Application No: BE/18/26/PL
Site Address: Land West of 26 Greystone Avenue Bersted PO21 5EA
Description of works: Erection of 1 No. detached four-bedroom dwelling (self build) with associated car parking, bike store and landscaping. This application is in CIL Zone 4 and is CIL Liable as a new dwelling.

Thank you for your internet representation made on 24th April 2026 which has been recorded as an objection with the comments as follows:

A :: Propopsed South East Elevation
01 scale: 1:100

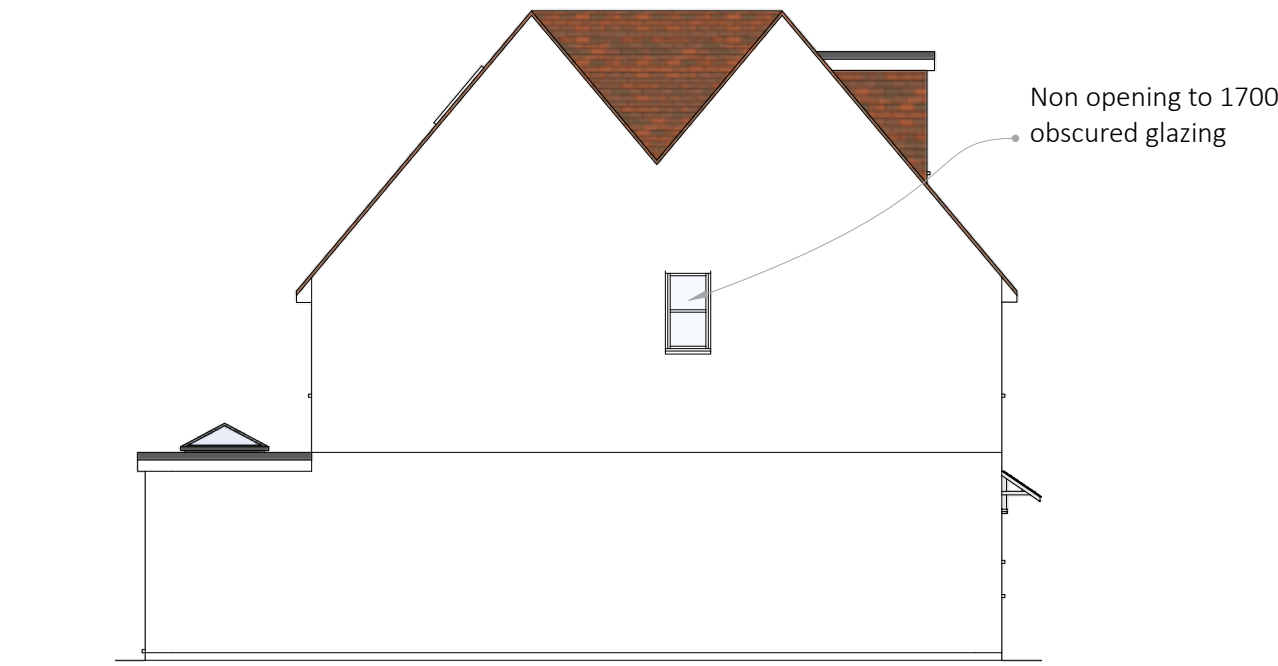
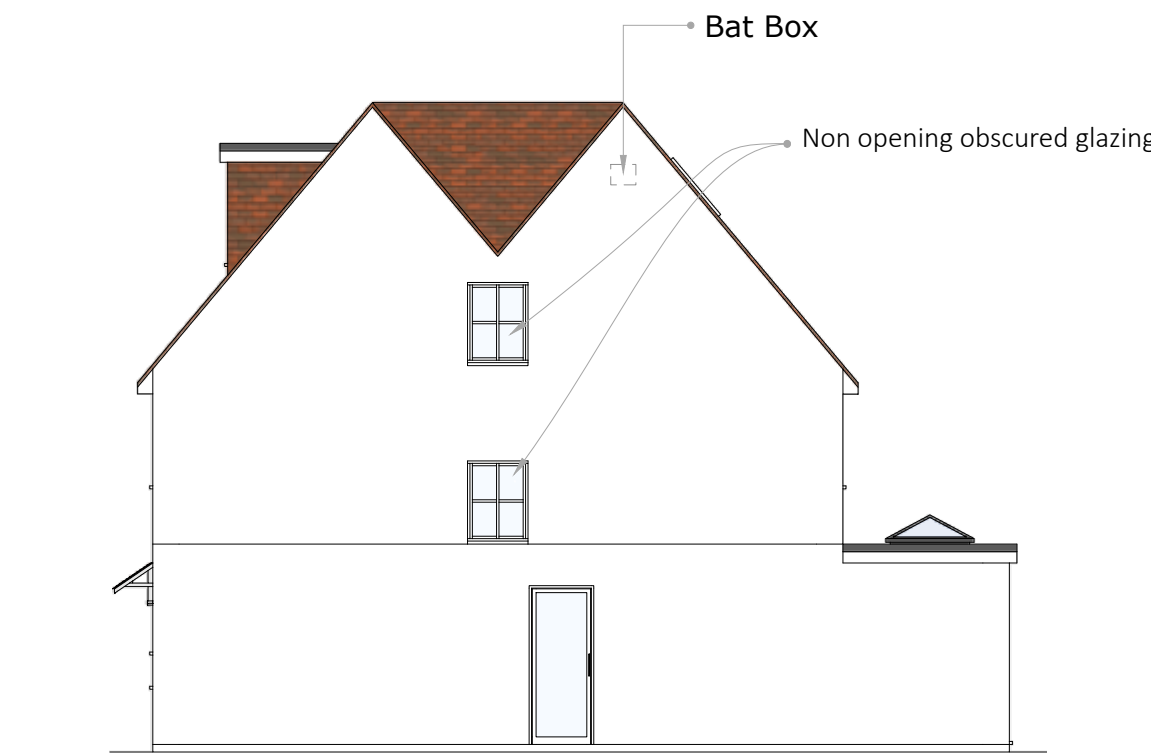
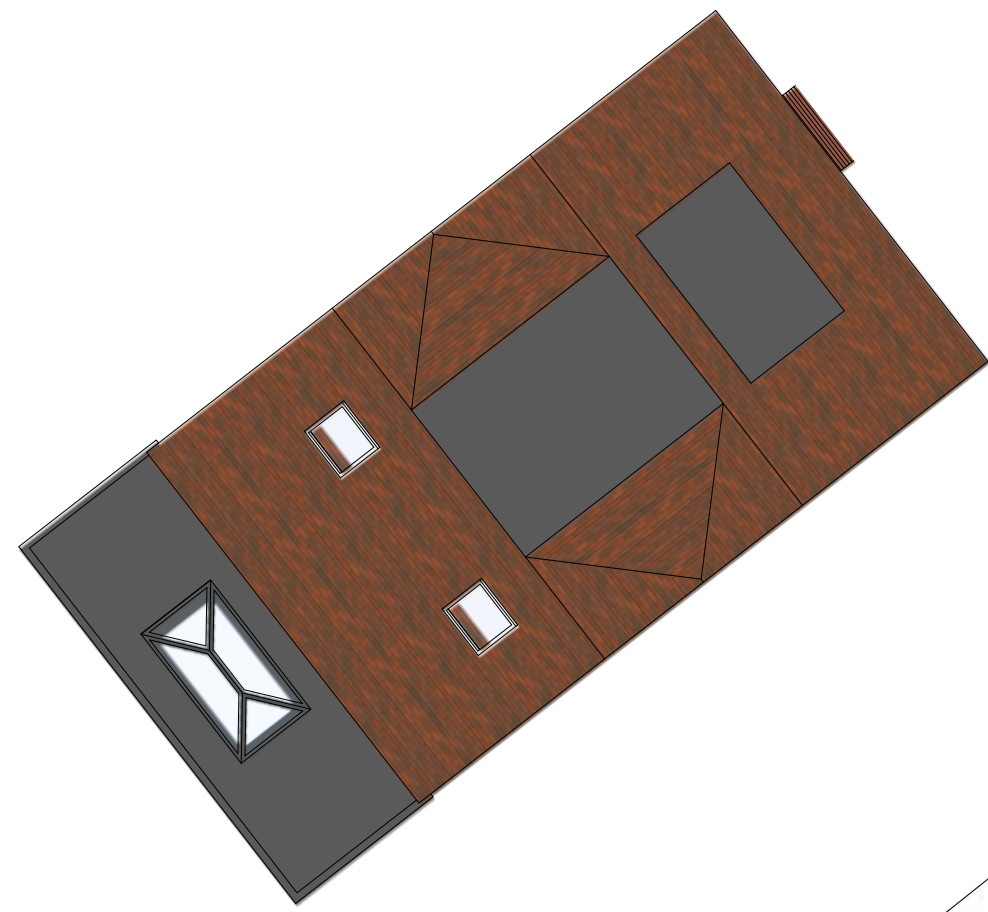
I wish to formally object to the above planning application. I have several concerns. While there are a mix of bungalows and two-storey properties in the wider area, the plot sits directly adjacent to a single-storey bungalow. The proposed dwelling, by virtue of its height, scale and massing, would appear dominant and overbearing in this immediate context. The inclusion of dormer windows gives the impression of a three-storey structure, which would further exacerbate the visual impact when viewed from the neighbouring bungalow and the adjacent cul-de-sac. This results in a form of development that fails to respond appropriately to its immediate surroundings and would cause harm to neighbouring amenity. Such as overlooking and loss of privacy. The development would directly overlook neighbouring properties, in particularly the bungalow at No. 26 Greystone Avenue. The elevated height and window placement, including dormers, would result in a significant loss of privacy and an overbearing impact on adjacent gardens, potential loss of light for No 26 and additional noise and disturbance.
